Subject: P/86/20/PL Bowley Farm, Bowley Lane, Pagham

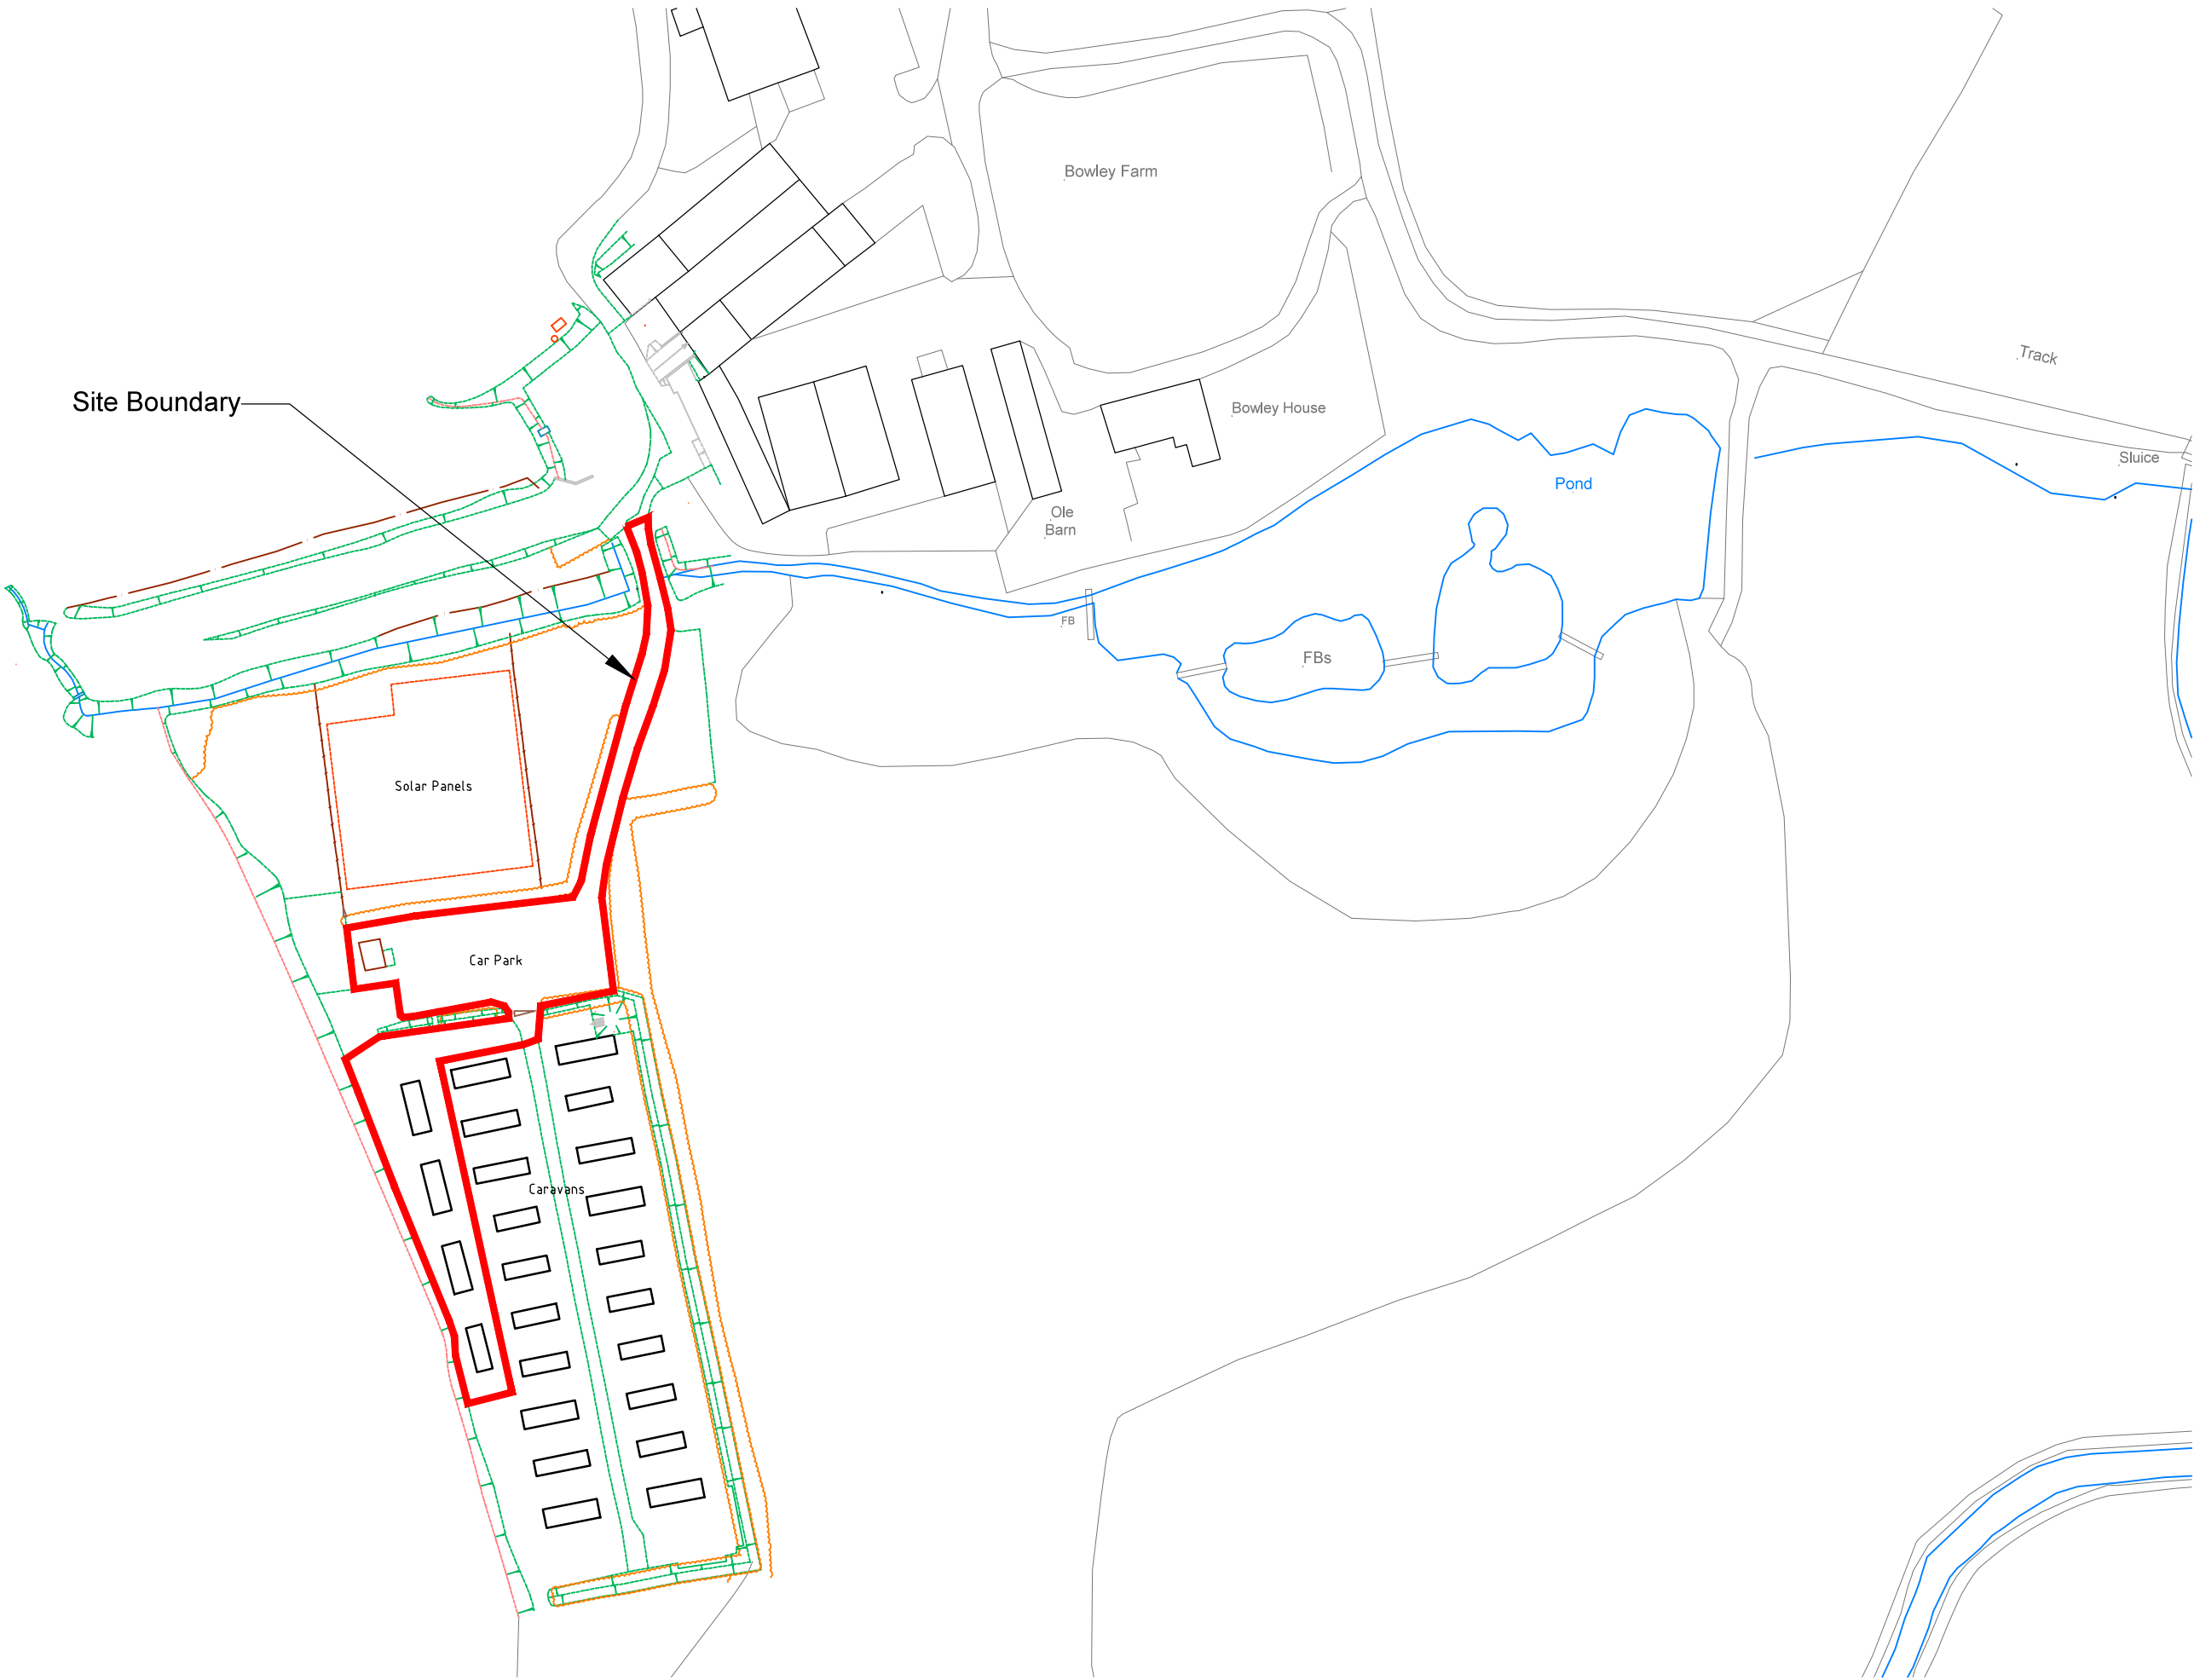
It has come to my attention that the access onto the site for the above is actually in Chichester District Council.

It has been suggested that if you blue edge the access into the site, the red edge will not be in Chichester any longer.

Can you please square off the red edge at the car park?
